Brown's Construction Solutions Ltd

Reference planning F/9/19/PL

Thank you for this opportunity to respond to the individual points raised on our application

Figure 3 Environment Agency's Flood Map

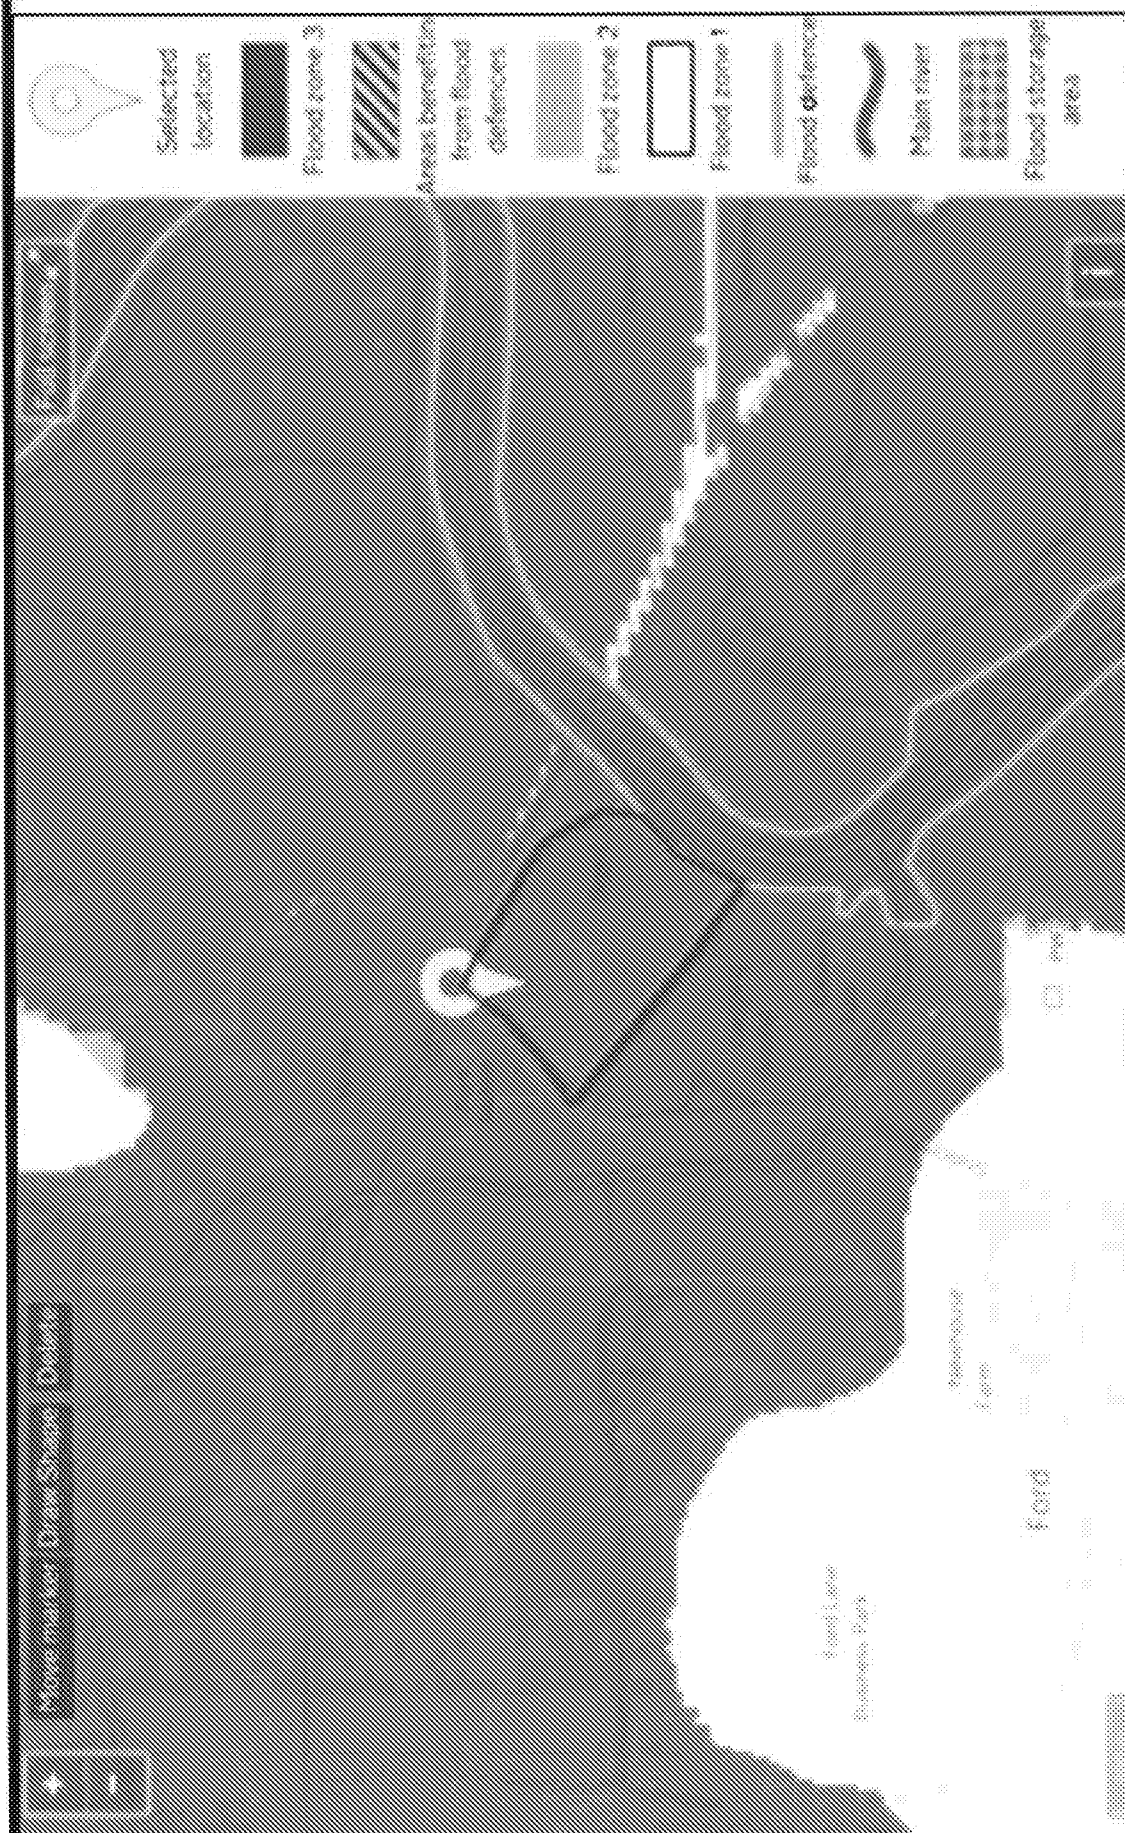
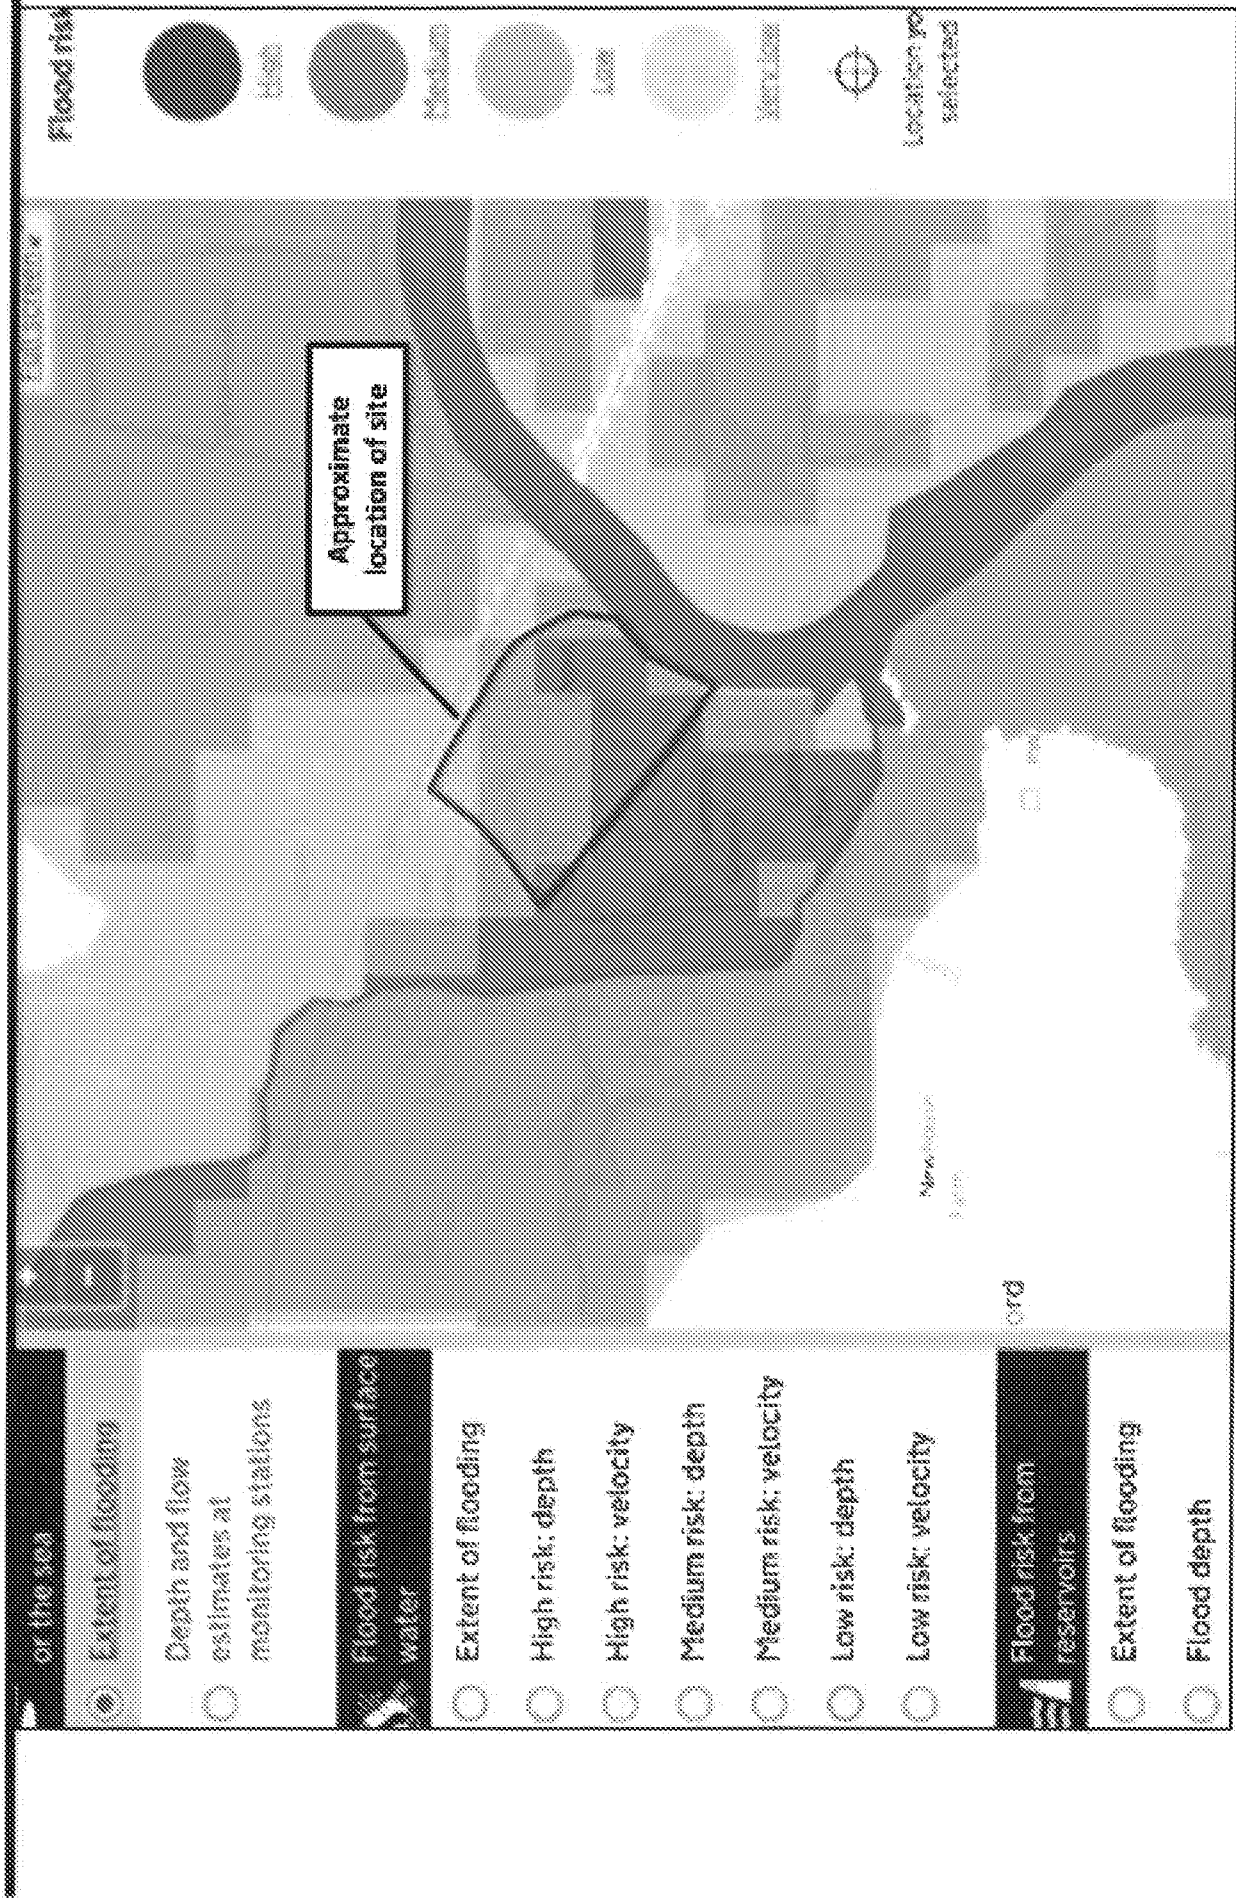
Paragraph 1 We appreciate the application is with in zone 3 and we are very happy to consult with the environment agency on all matters relating to the flood zone and the necessary actions / precautions that may be needed to ensure we do not compromise the current situations. We would be happy to accept reasonable conditions with in the consent

Proposed entrance and hard standing
alteration with change of use

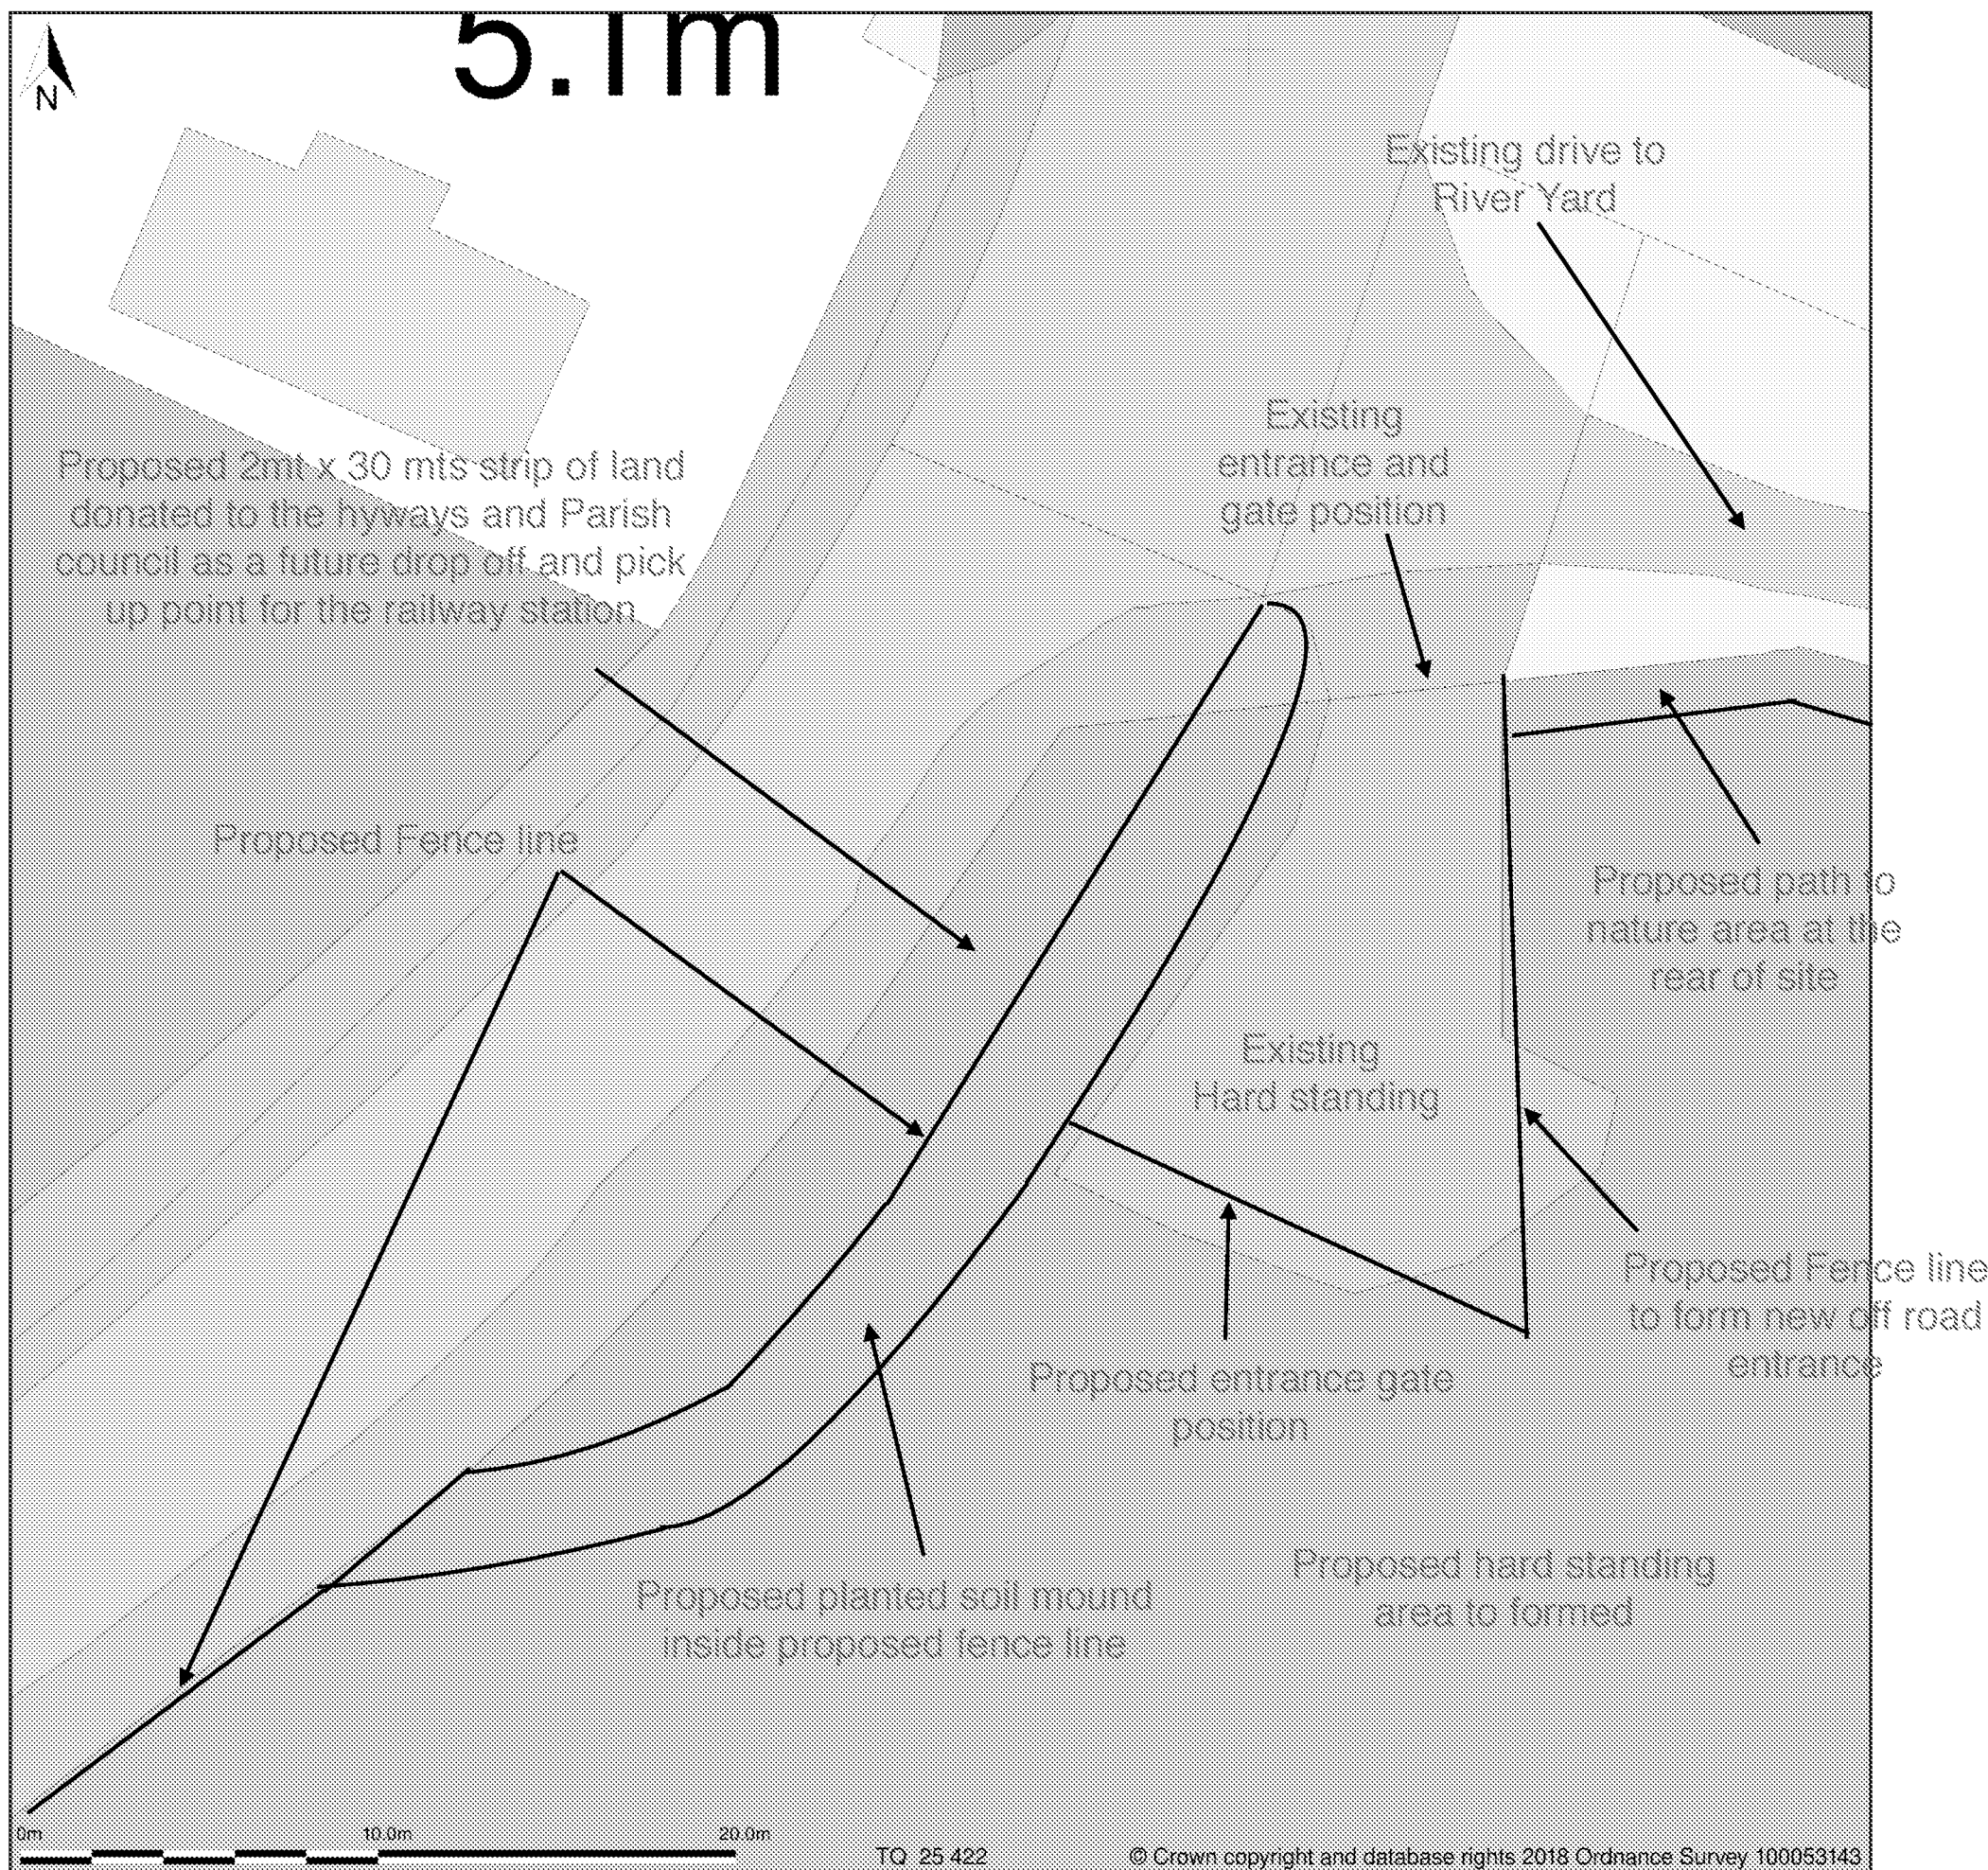
Paragraph 4 we currently have not proposed an amended to the entrance splays, as it is our intension to have a full consultation with the highway authority once we have a commitment from the council regarding our application. We are happy to revise the entrance splay to comply with TD9/93.

Paragraph 5 We are happy to produce the swept path-tracking document. As it has

been our intension for all vehicles to enter the site completely and have adequate room to manoeuvre on site and leave in a forward direction.

Paragraph 7 We are happy to supply the plan as requested and we will be having a restricted number of contains, these will be positioned in areas of reduced visibility on the site and will not be stacked at any point.
